**KIRKLEES COUNCIL
TOWN AND COUNTRY PLANNING ACT 1990
HIGHWAYS DEVELOPMENT MANAGEMENT**

PLANNING REF 2018/62/91866/E0/AM
CATEGORY Minor

PROPOSAL DEMOLITION OF EXISTING
DWELLING AND ERECTION OF 4
DWELLINGS

LOCATION 1 OUZLEWELL LANE
THORNHILL LEES
DEWSBURY
WF12 9EP

Site Roof Plan As Proposed
Scale 1:200
0m 5m 10m

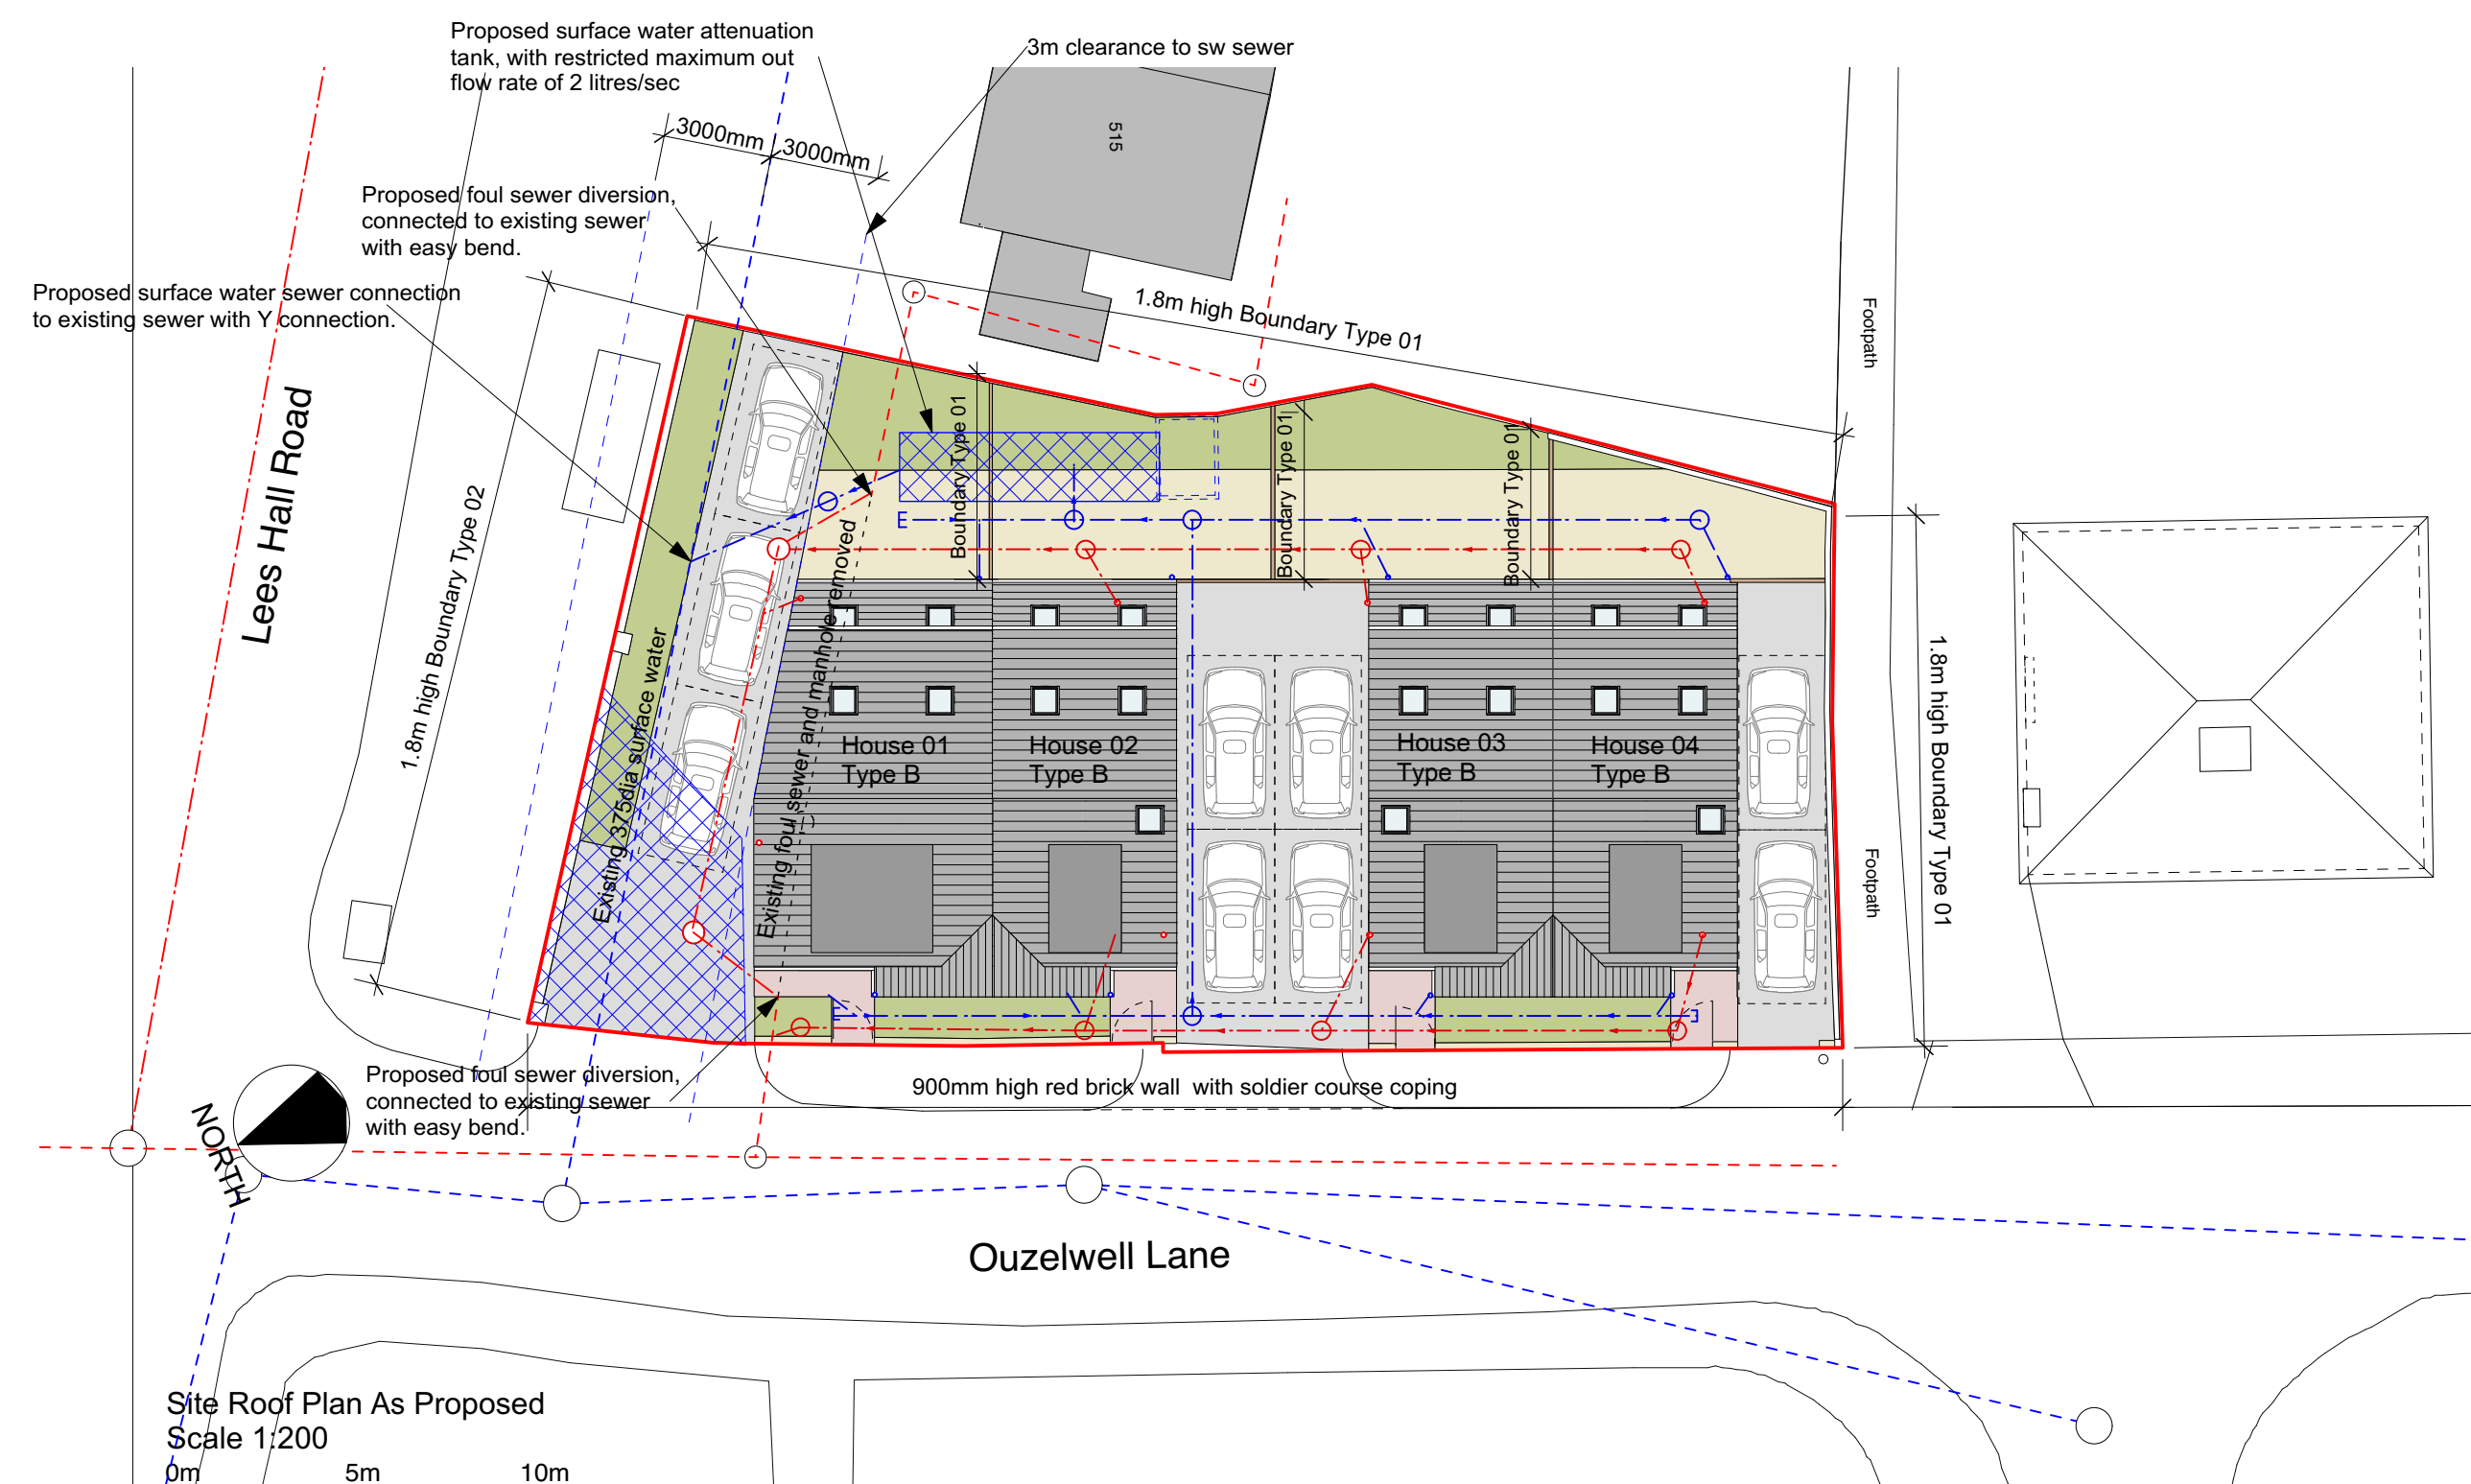
The proposed parking provision is in line with the councils parking policy and is considered acceptable. It is noted however that part of the proposed parking area is on land that is owned by the Council adjacent to the development, as such the parking provision would only be considered acceptable utilising this area.

The provision for storage and collection of waste from the premises has not been indicated on the submission.

Before development commences details of storage and access for collection of wastes from the premises shall be submitted to and approved in writing by the Local Planning Authority. The approved details shall be provided before first occupation and shall be so retained thereafter.
